ASSESSMENT REPORT

Section 75W Modification MIRANDA DENTAL HOSPITAL MP 11_0009 MOD 4

Signage 7
Kiora Road scale: 1:50

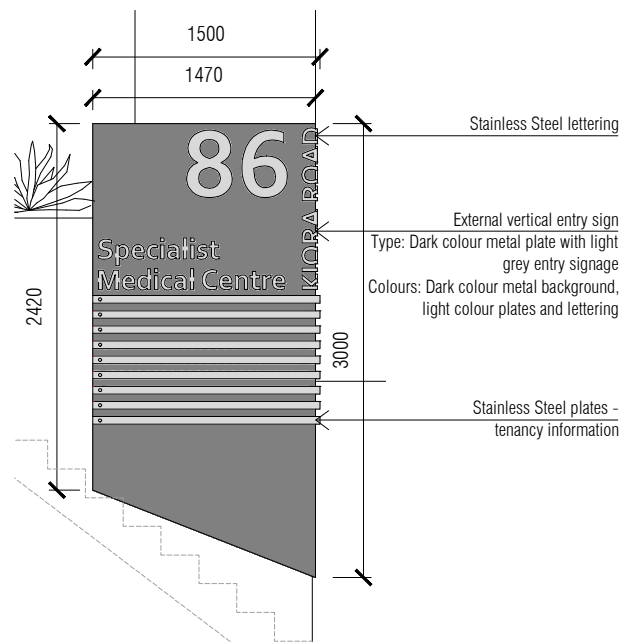
- Increase the number of building identification signs from six to seven with an additional sign on western awning.

- the proposed changes to the southern elevation are acceptable in principle but further clarification of the façade treatments, materials and finishes should be provided.
- the proposed new sign is acceptable provided it does not protrude below the approved awning.

<i>Signage</i>	• The proposed modification includes the erection of one additional business identification sign on the western awning (Figure 2). • Council advised the sign would be acceptable provided it does not protrude below the approved awning. • The Department has considered the additional signage against the requirements of State Environmental Planning Policy 64 – Advertising and Signage and is satisfied the proposed sign would be adequately integrated into the overall building design, would not protrude below the approved awning structure and would be consistent with the commercial character of the area. • The Department is therefore satisfied the proposed signage would not result in any adverse visual impacts and is appropriate for the site.	No additional conditions or amendments necessary.
<i>Internal Design Changes</i>	• The proposal incorporates minor changes to the lower ground floor level including lowering the floor level to facilitate level entry from Kiora Road and a minor change to the internal stair profile. • The Department considers the minor changes would improve access to the site and would not result in any adverse impacts.	No additional conditions or amendments necessary.

SOUTH & WEST ELEVATIONS

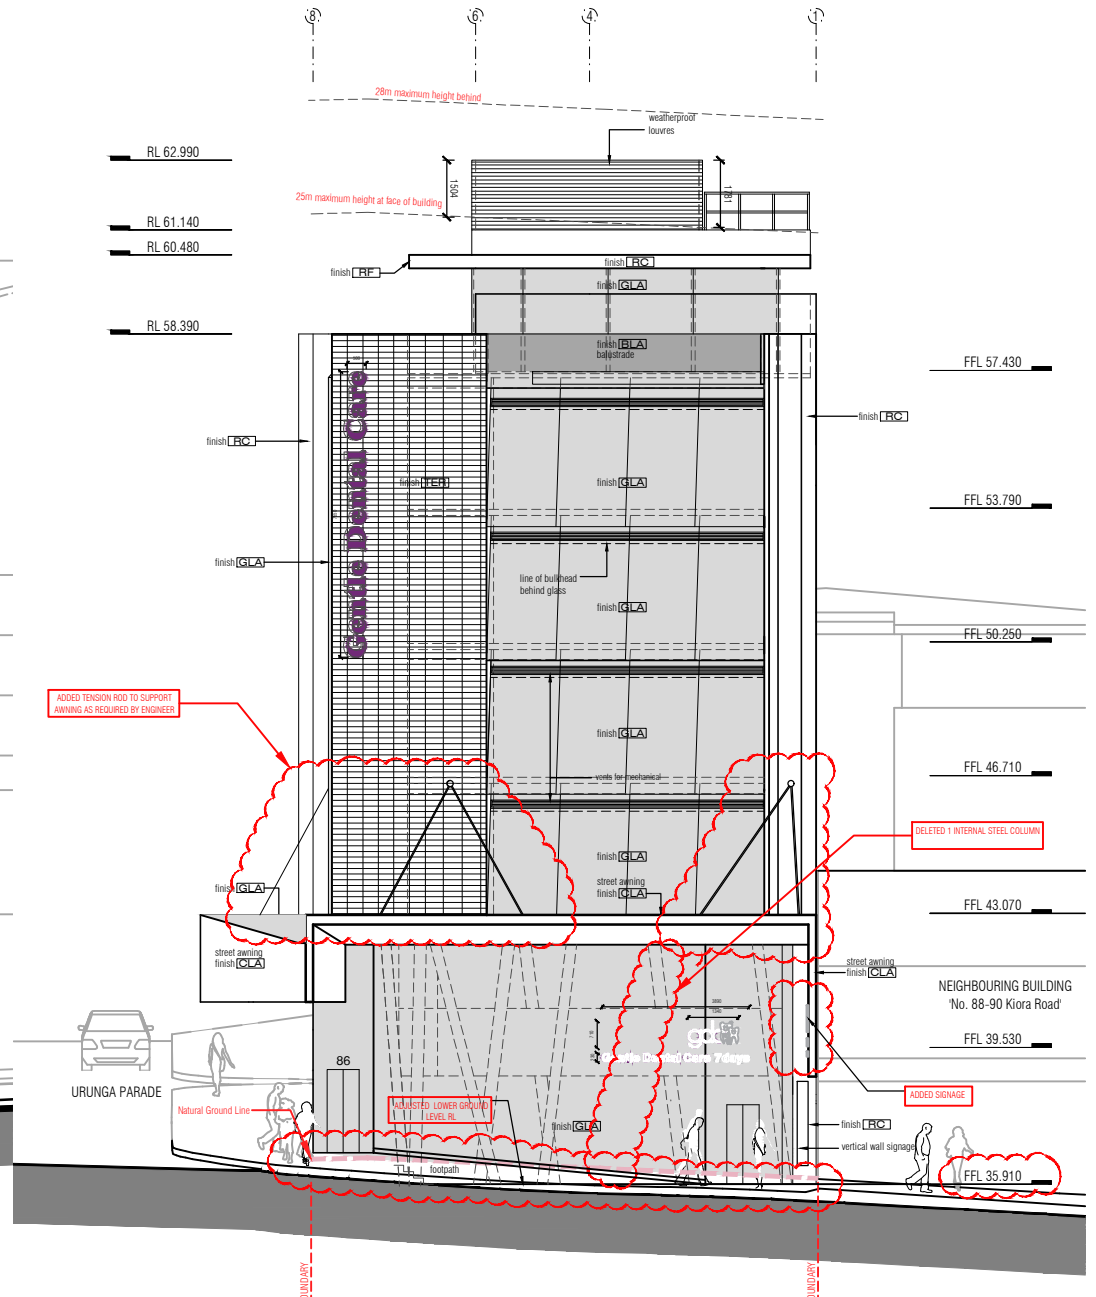
Issue	Consideration	Recommendation
External Design Changes	• Key changes to the external finishes include: – Change in southern façade from patterned white concrete to aluminium cladding and concrete to chromatic purple cladding and associated change to window sill height (Figure 3) – Air plenum on northern elevation reduced in size and image updated – Security panel lift door added to driveway entry – Above awning tensile rods added to support awning	No additional conditions or amendments necessary.

<i>Issue</i>	<i>Consideration</i>	<i>Recommendation</i>
	- Deletion of an inclined column on western elevation - Minor change to column shape at south-west corner of building • The Department initially raised concerns about the proposed use of metallic cladding on the southern façade of the building as it could result in additional visual impacts, particularly if the building material is highly reflective. • The Proponent clarified the cladding has a reflectivity index of only 7.32%, well below the usual 20% reflectivity guideline. • The Department considers the proposed changes to the southern elevation would not result in unacceptable visual impacts, noting: - the elevation faces south and therefore will be in shadow at most times - the cladding is not highly reflective and is unlikely to be significantly more reflective than the approved white painted concrete finish - the change relates to the 'rear' elevation which does not face a public road. The façade is only visible because the neighbouring site is not yet developed. Once developed, the neighbouring site would obscure any views of the cladding. • The Department has reviewed all of the other design changes and is satisfied the changes are minor and would not significantly alter the overall appearance of the building or result in any unacceptable visual impacts. Overall, the building would retain a range of high quality façade elements and finishes, ensuring it makes a positive contribution to the streetscape.

On 27 February 2018 the Proponent submitted a Response to Submissions (RTS) and submitted additional information on 15 March 2018 to clarify the materials proposed for the southern elevation and address the matters raised by Council.
